**Our Ref: LU/214/13/
Your Ref:**

Application for Planning Permission for Works or Extension to a Dwelling

Development Storage shed in rear garden
Location 42 Penarth Gardens Thornlea Park Littlehampton

BLOCK PLAN.

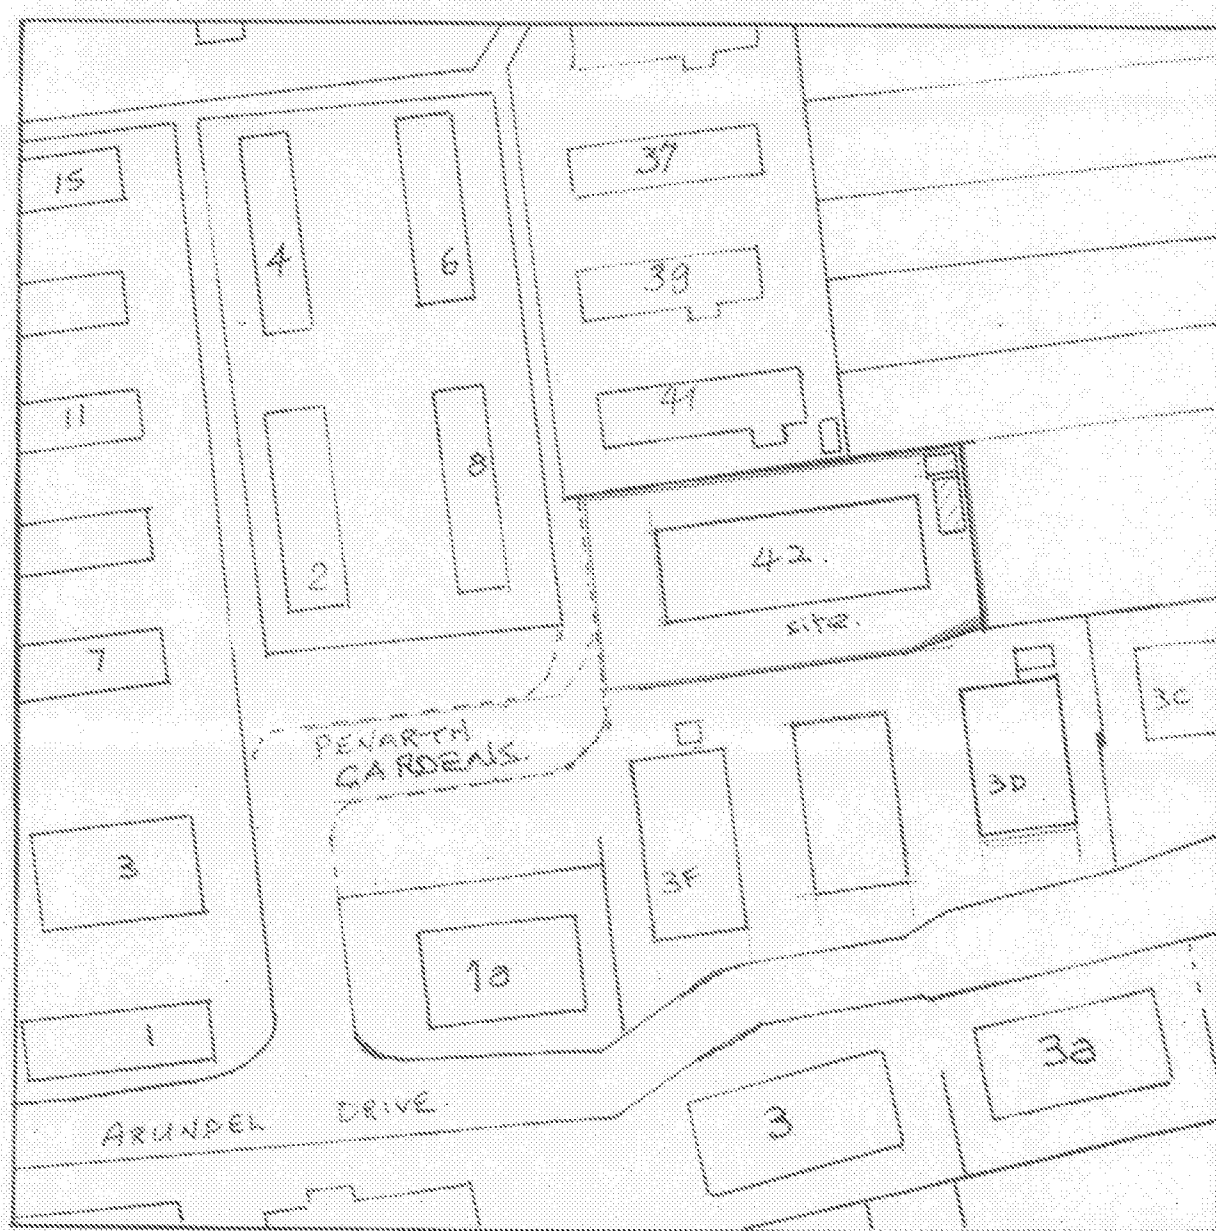
Block Plan

Please submit 1 electronic or 3 paper copies of a revised block/site plan with written dimensions including those to the boundaries at a scale of 1:500 or 1:200. Further details of what must be included on the plan can be found in the National Validation Requirements.
